Subject: Eagle Rising SF2225 Plat Filing 1

Our responses to the EPC review December 2023 Plat and related document comments have uploaded EDARP. The upload includes: this Applicant Comment Response Letter, Construction Drawings, Detention maintenance agreement, Financial Assurance Estimate, Final Drainage Report, Final Plat, GECP, LOI, ESQCP, WSIS, SWMP, Grading & Erosion Control Check List, PDB/BMP Operations & Maintenance Manual, SWMP Check List, PDWD Commitment Letter, Water Resources Report/Support Document.

Submittal N	EDARP Review Comments														
Project Name	Eagle Rising Final Plat Filing No. 1 (Minor) SF2225														
Comment Number ID	Document Submitted	Agency	Attachments	Reviewer Name	Reviewer Date	Redline Document	Page	Reviewer Comment	Applicants Disposition	Applicant Response Date	Document	Page	Applicant Comment/Response	El Paso County Response	
1	Financial Assurance Forms Eagle Rising Filing No 1	PCD Engineering Division	Yes	Glenn Reese	12/6/2023 18:55	(FAE redlines)	1	Verify that this includes the full RPA area that is currently unvegetated.	E - Answer provided	5/21/2024	Financial Assurance Forms Eagle Rising Filing No 1	-	RPA areas shown on the Final Dra

CIVIL CONSULTANTS, INC.
 212 N. WAHSATCH AVE., STE 305
 COLORADO SPRINGS, CO 80903
 PHONE: 719.955.5485
 SHEET 2 OF 5

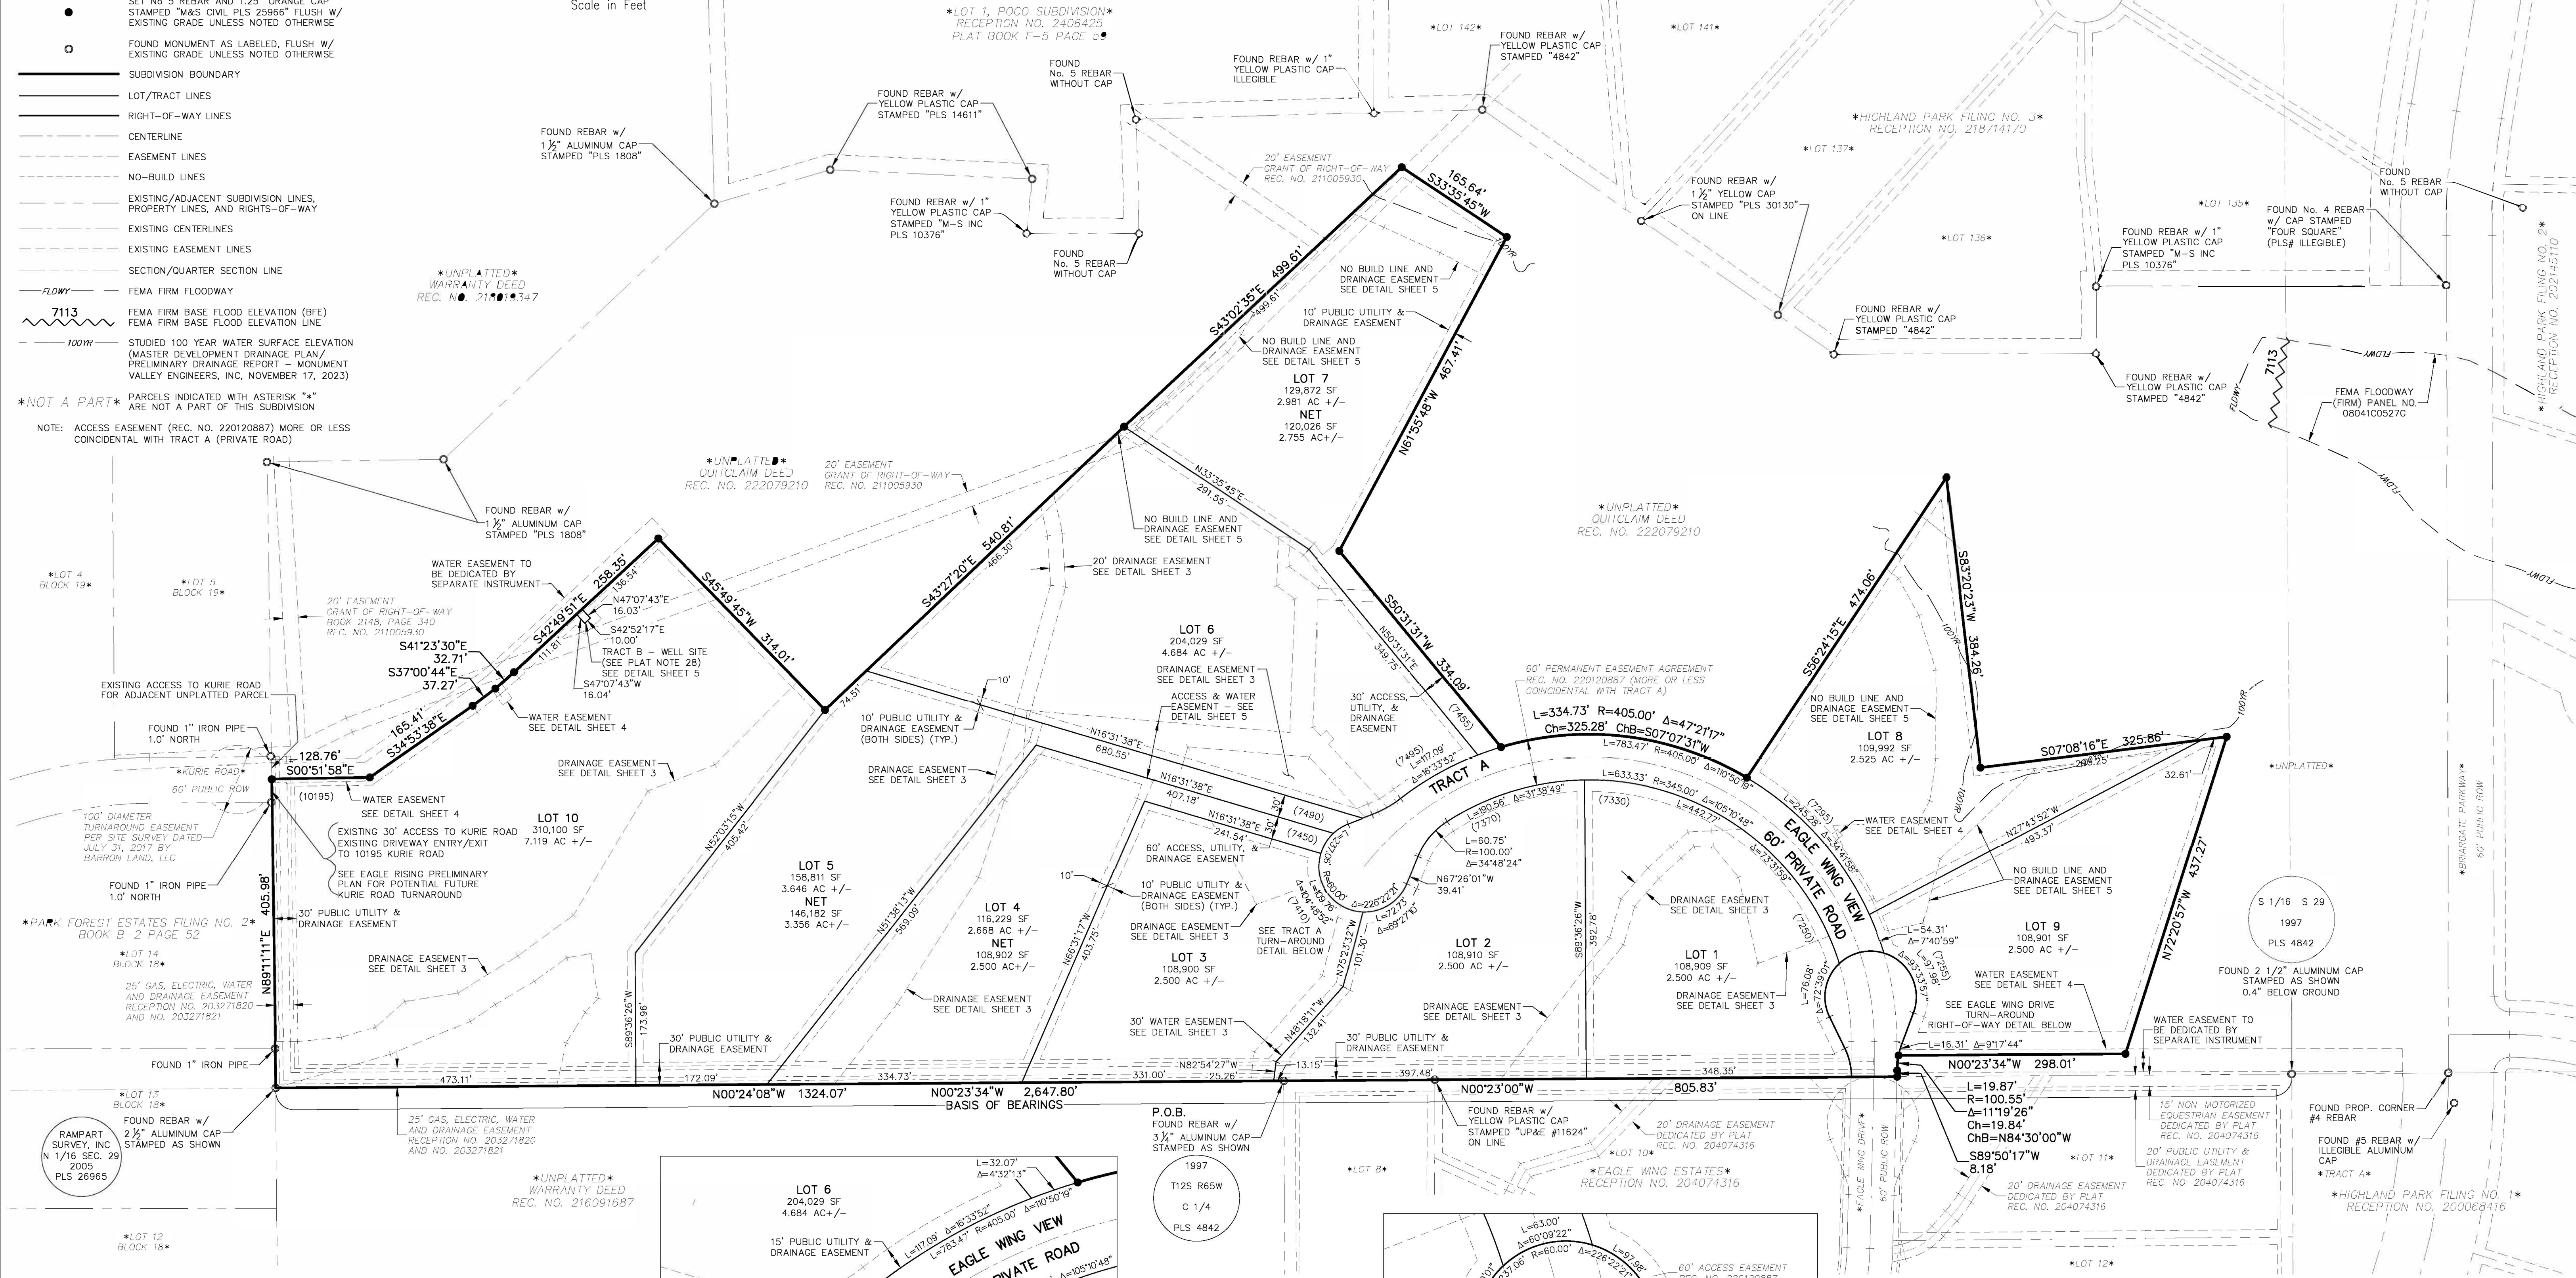
27	Final Plat Eagle Rising Filing No 1	PCD Engineering Division	Yes	-	12/6/2023 18:48	(Plat redlines)	2	Half of ROW to be platted not just a easement	C - Disapproved	5/21/2024	Final Plat Eagle Rising Filing No 1	-	<p>From the previous response on 11.20.23 (Eagle Rising SF2225 11.20.2023 Letter to EPC Planning w_ PLAT Tracker via EDARP)</p> <p>An additional Kurie Road Cul-de-Sac Right of Way is not required on Final Plat Eagle Rising Filing No. 1. Not required per Palmer and Kilgore from Meeting Minutes on 10/25/23 with EPC staff. El Paso County required to maintain current Kurie Road Cul-de-Sac road according to El Paso County standards .</p> <p><u>Additional response to EPC 12/6/23 comment</u> The Preliminary Plan shows the complete development of two parcels, 5229000034 and 5229000035. Eagle Rising Filing No. 1 is the final plat for only the western parcel (5229000034). The final plat for Filing No. 1 contains the necessary elements to serve the single-family residential lots as depicted on the Filing No. 1 plat. The approved Preliminary Plan indicates a turnaround will be required for more than two parcels/lots to access Kurie Rd.</p> <p>El Paso County accepted the current Kurie Road Cul-de-sac in 1960. The current parcel 5229000034 has legal access easement to the established and existing Kurie Road cul-de-sac. This is not changed by the approval of the Preliminary Plan.</p> <p>An additional Kurie Road Cul-de-Sac Right of Way is not required on Final Plat Eagle Rising Filing No. 1. Minimum frontage access meets LC 8.4.3.B.e as shown on the plat. See Detail Sheet 3 showing the established and existing approved driveway 30' access for the current parcel access to Kurie Road that is platted as a permanent existing turnaround. No new road is created by the Eagle Rising Filing No 1 Plat. No additional ROW needed.</p> <p>This may become a RIPRA Colorado Statues violation.</p>

28	Final Plat Eagle Rising Filing No 1	PCD Engineering Division	Yes	-	12/6/2023 18:48	(Plat redlines)	2	<p>Correct Plat</p> <p>Add half of the ROW for the Cul de sac per ECM Std 2.-76 for Rural and add clarifying plat note/condition when the Cul-de-sac will be installed. If revision of the cul-de-sac design are proposed then the Prelim Plan needs to be amended</p>	C - Disapproved	5/21/2024	Final Plat Eagle Rising Filing No 1	-	<p>From the previous response on 11.20.23 (Eagle Rising SF2225 11.20.2023 Letter to EPC Planning w_ PLAT Tracker via EDARP)</p> <p>An additional Kurie Road Cul-de-Sac Right of Way is not required on Final Plat Eagle Rising Filing No. 1. Not required per Palmer and Kilgore from Meeting Minutes on 10/25/23 with EPC staff. El Paso County required to maintain current Kurie Road Cul-de-Sac road according to El Paso County standards .</p> <p><u>Additional response to EPC 12/6/23 comment</u> The Preliminary Plan shows the complete development of two parcels, 5229000034 and 5229000035. Eagle Rising Filing No. 1 is the final plat for only the western parcel (5229000034). The final plat for Filing No. 1 contains the necessary elements to serve the single-family residential lots as depicted on the Filing No. 1 plat. The approved Preliminary Plan indicates a turnaround will be required for more than two parcels/lots to access Kurie Rd.</p> <p>El Paso County accepted the current Kurie Road Cul-de-sac in 1960. The current parcel 5229000034 has legal access easement to the established and existing Kurie Road cul-de-sac. This is not changed by the approval of the Preliminary Plan.</p> <p>An additional Kurie Road Cul-de-Sac Right of Way is not required on Final Plat Eagle Rising Filing No. 1. Minimum frontage access meets LC 8.4.3.B.e as shown on the plat. See Detail Sheet 3 showing the established and existing approved driveway 30' access for the current parcel access to Kurie Road that is platted as a permanent existing turnaround. No new road is created by the Eagle Rising Filing No 1 Plat. No additional ROW needed.</p> <p>This may become a RIPRA Colorado Statues violation.</p>

30	Final Plat Eagle Rising Filing No 1	PCD Engineering Division	Yes	-	12/6/2023 18:48	(Plat redlines)	2	Only platting 8 lots. This is not a sequential number from lot #7. Lot #8 is the next sequential #	C - Disapproved	5/21/2024	Final Plat Eagle Rising Filing No 1	-	From the previous response on 11.20.23 (Eagle Rising SF2225 11.20.2023 Letter to EPC Planning w_ PLAT Tracker via EDARP) Subjective. No change required as current Final Plat Eagle Rising Filing No. 1 is compliant to 7.2.5.C Additional response to EPC 12/6/23 comment Eagle Rising Filing No.1 is 10 lots. Lots are sequential around Eagle Wing View as shown on the Preliminary Plan.	
31	Final Plat Eagle Rising Filing No 1	PCD Engineering Division	Yes	Ryan Howser	12/6/2023 18:48	(Plat redlines)	2	Unresolved comment from previous review: lot numbering shall be sequential per LDC Sec. 7.2.5.C.1, which states: Sequential Numbering. The numbering of lots shall follow a sequential numbering pattern.	C - Disapproved	5/21/2024	Final Plat Eagle Rising Filing No 1	-	From the previous response on 11.20.23 (Eagle Rising SF2225 11.20.2023 Letter to EPC Planning w_ PLAT Tracker via EDARP) Subjective. No change required as current Final Plat Eagle Rising Filing No. 1 is compliant to 7.2.5.C Additional response to EPC 12/6/23 comment Eagle Rising Filing No.1 is 10 lots. Lots are sequential around Eagle Wing View as shown on the Preliminary Plan.
